From: Roger Spencer
Sent: 14 November 2017 17:12
To: Richard Temple
Subject: RE: Barfoots Sefter farm Sweetcorn extension P/107/17/PL

From: Richard Goodall [REDACTED]
Sent: 14 November 2017 14:19
To: Richard Temple
Subject: Barfoots Sefter farm Sweetcorn extension P/107/17/PL

Having reviewed the existing yard slab further in the vicinity of the proposed building it appears, for the footprint of the proposed building, that the yard is drained partly to the existing foul system and partly through surface run-off to the existing undeveloped field area. With this new development we propose to improve the situation and divert the new roof drainage to the adjacent reservoir. This reservoir has a surface area of approximately 10,000m² and furthermore is part of an interlinked network of reservoirs whose levels are managed to suit farming needs.

client	BARFOOTS OF BOTLEY LTD.		
project	Seffer Farm Packhouse 1 Corn Extension		
title	Proposed Block Plan

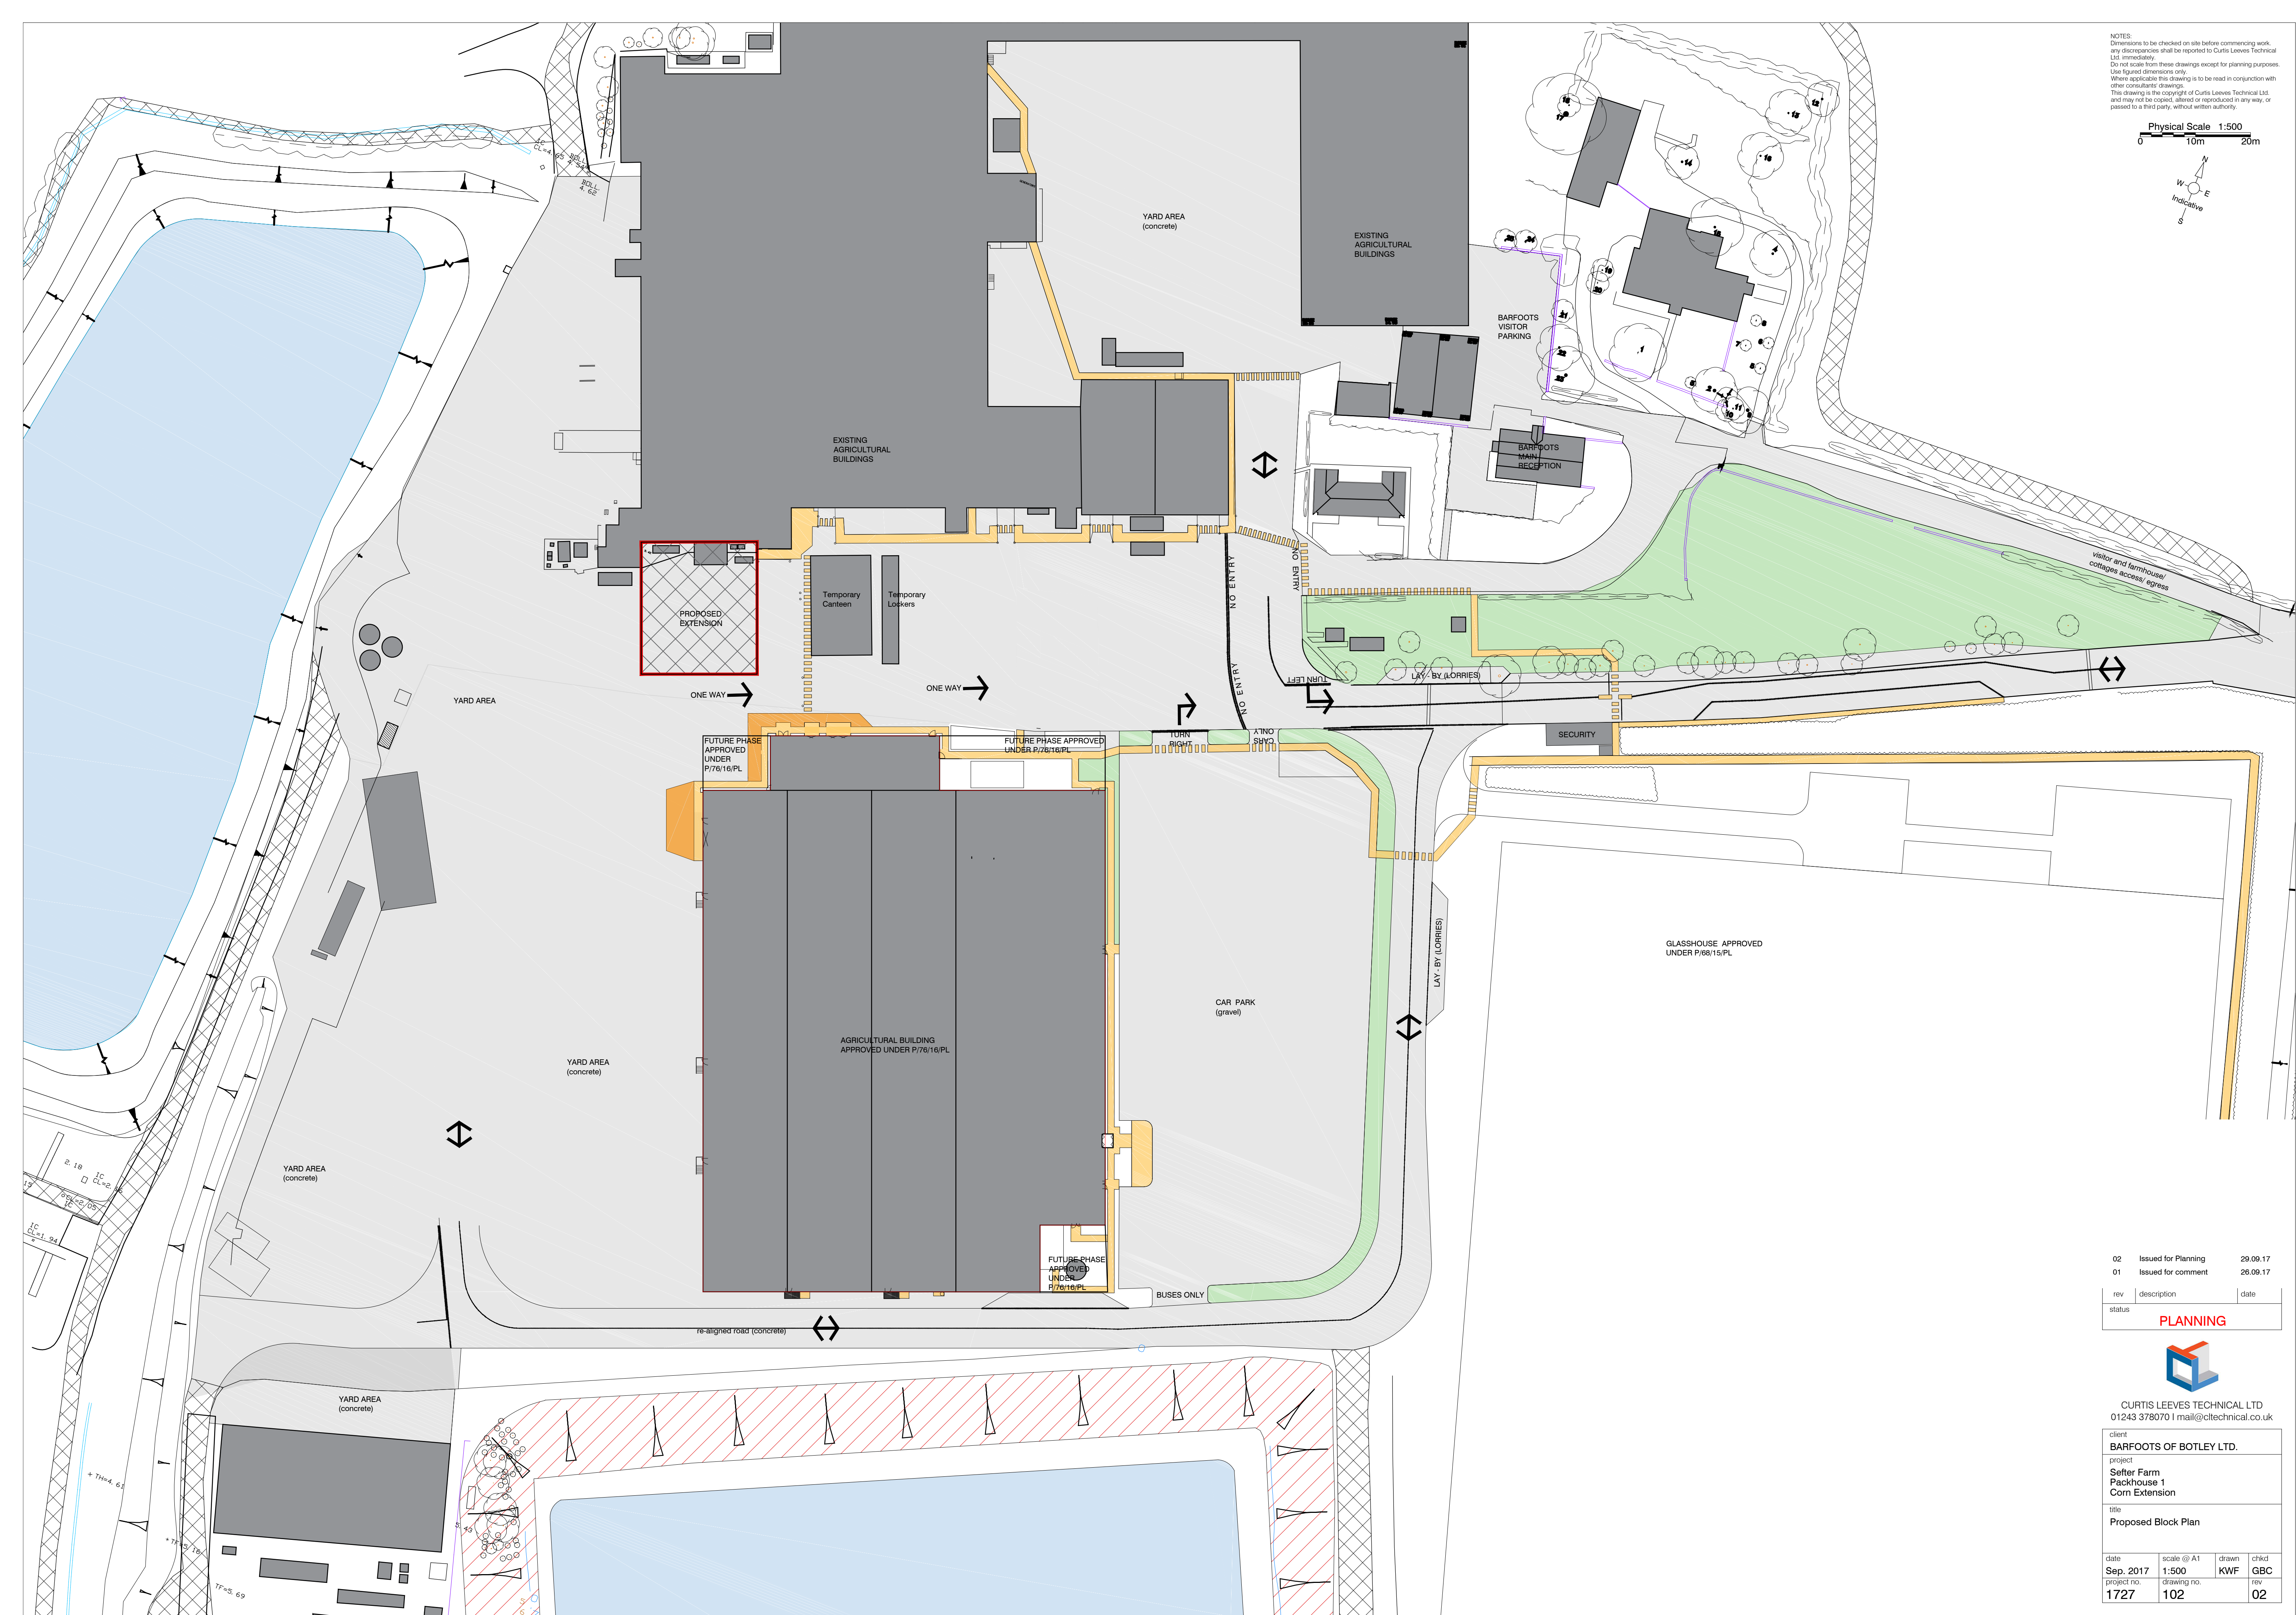
I don't think that you have alerted me to this yet but I have picked up Roger Spencer's drainage comments regarding the above.

This proposed building roof area represents a small percentage of the reservoir network capacity, and would create a negligible increase in water levels. The reservoir is maintained by the farm through frequent inspection, to ensure water levels are at the correct levels, and to a freeboard of approximately 500mm. This will continue to be the case with all planned developments for the site. Therefore, on conclusion of the proposed extension, there will be a net reduction in the potential for the existing developed areas of the site to contribute directly into the flood-zoned area."
